Planning Officer: Charlotte Easton
Planning Application Ref: EG/5/19/T
Location: 111 Barnham Road, Barnham, PO22 0EQ
Description of works: Raise crown to 2.4m to 1 no. Monterey pine tree
Reasons Given: Potential for damage to property

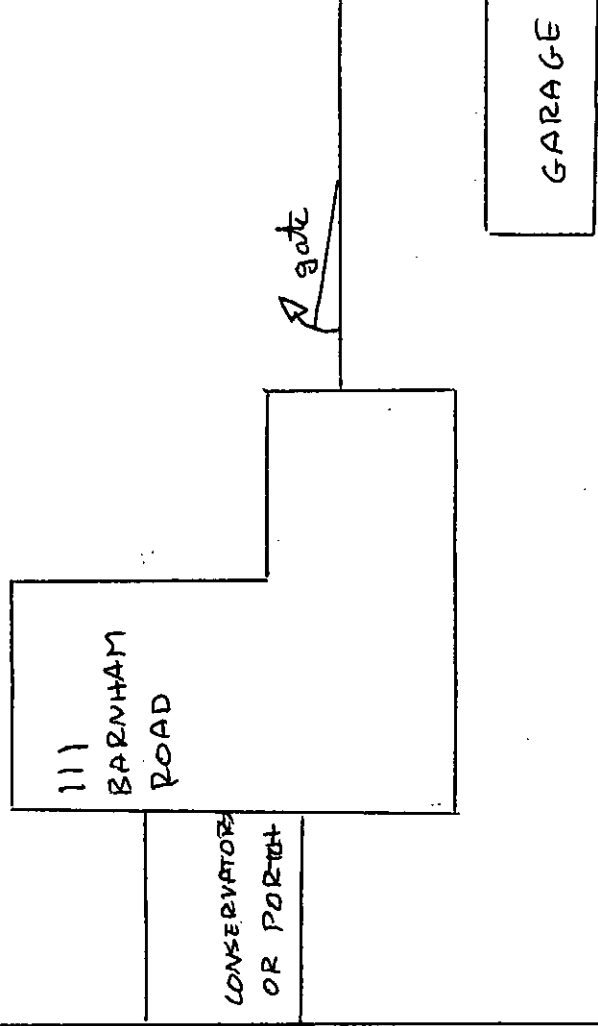
- The applicant is proposing the removal of a single branch that risks direct damage to their boundary fence line. The offending branch is small (<100m diameter), discreetly located within the adjacent understorey and is dead.

- The 'live' crown is in excess of 2.4m height, and so there seems to be no proposal for the removal of any foliage-bearing limbs/branches.
- If the applicant is proposing the removal of any 'live' growth (usual when *crown lifting* is specified) then this has not been made explicit. The large and obvious low limb tending south from the tree should be retained but if it is their intention to remove it we would need them to make that clear.

- The offending branch is small (<100m diameter), discreetly located within the adjacent understorey and is dead. As such, it is an exception from the normal application process and can be removed (as with all and any dead branches) without requiring permission from the local planning authority.
- If the applicant advises that they intend to remove the large low limb then I would not raise an objection to such work, but a new application will be required and only then could consent be given subject to an appropriate condition being applied (which I can provide).

- I recommend the applicant is advised of the contents of this report and informed that they can proceed with the removal of any dead branches without further recourse to this authority.
